OBJECTION

State Significant Development Application No: SSD-10300
Coffs Harbour Cultural and Civic Space

RIDING LANE ELEVATION

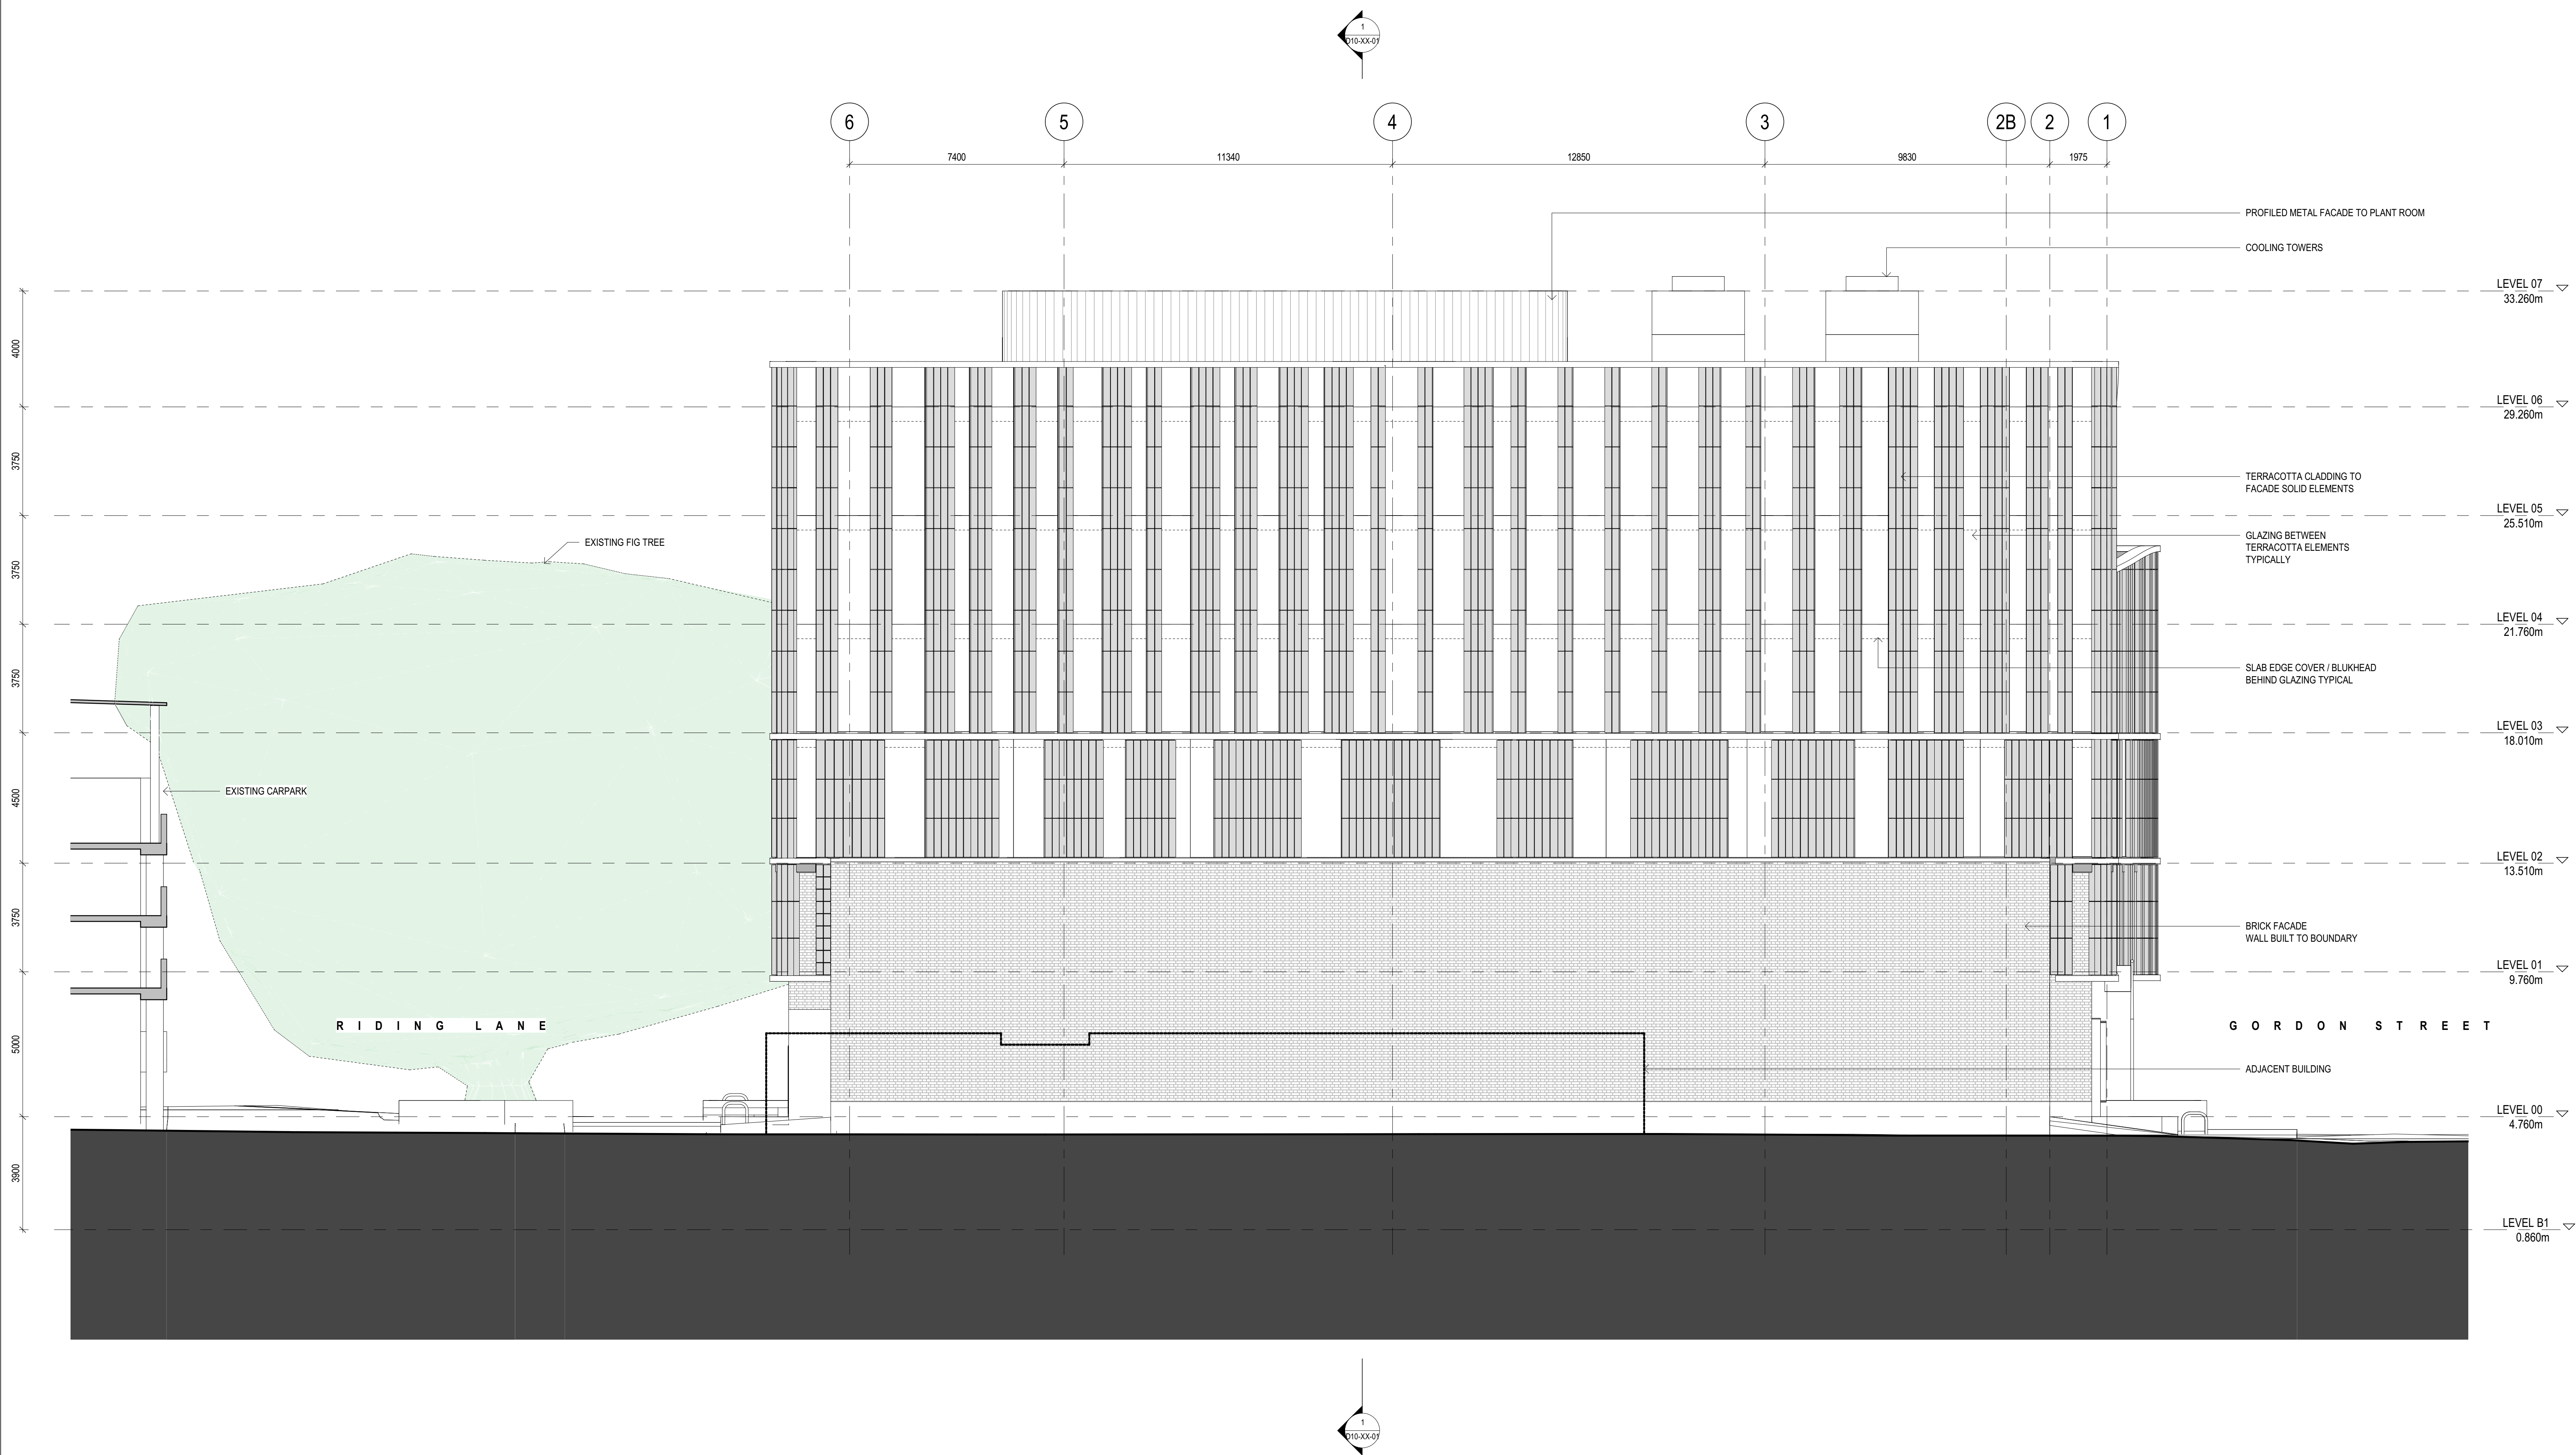
6. The proposal does not meet "safer by design" principles and guidelines, as the arcade to Riding Lane confuses boundaries and provides "hides" for criminal activity, vagrancy and prevents good surveillance.

SECTION N-S

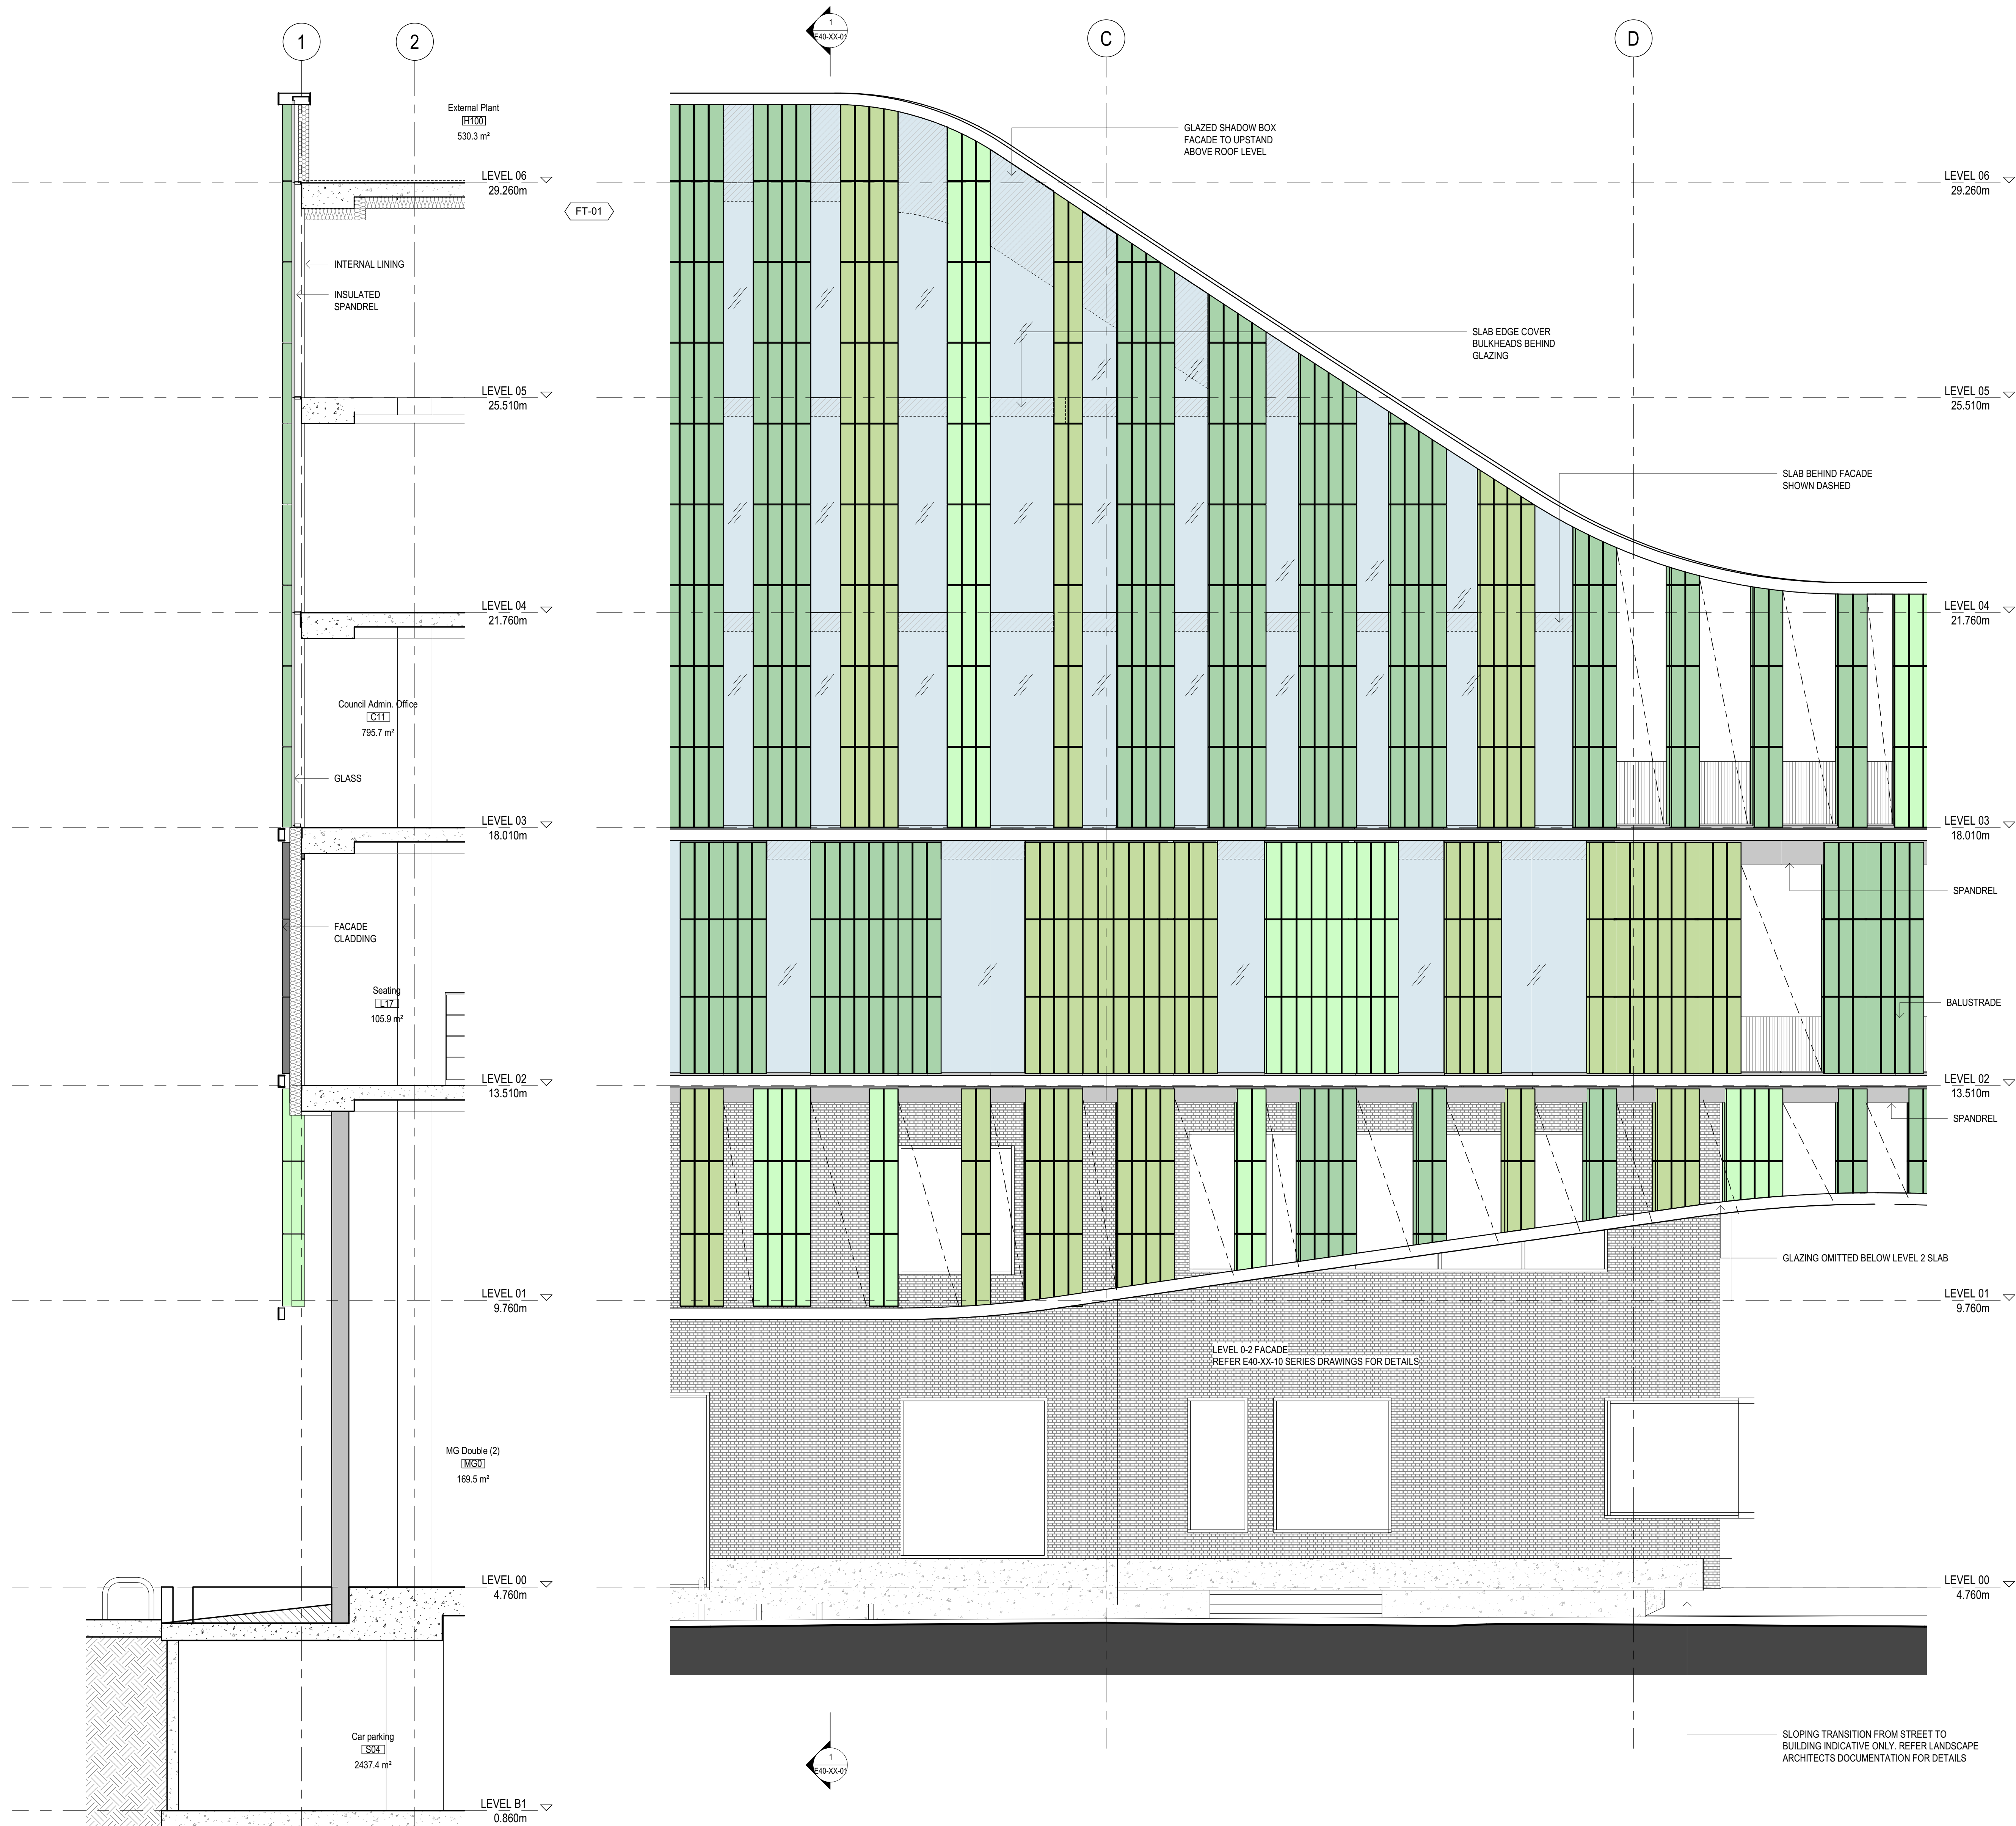
7. As a public building it fails to provide sufficient climate protection for pedestrians during storms and summer sun.
8. The building exceeds the height restriction of 28m set down in Council's own planning controls. Council's argument for variation is not satisfactorily justified and is not consistent with the objectives of the Environmental Planning and Assessment Act 1979, which requires the "the orderly and economic use and development of land". Council should not receive preferential treatment.
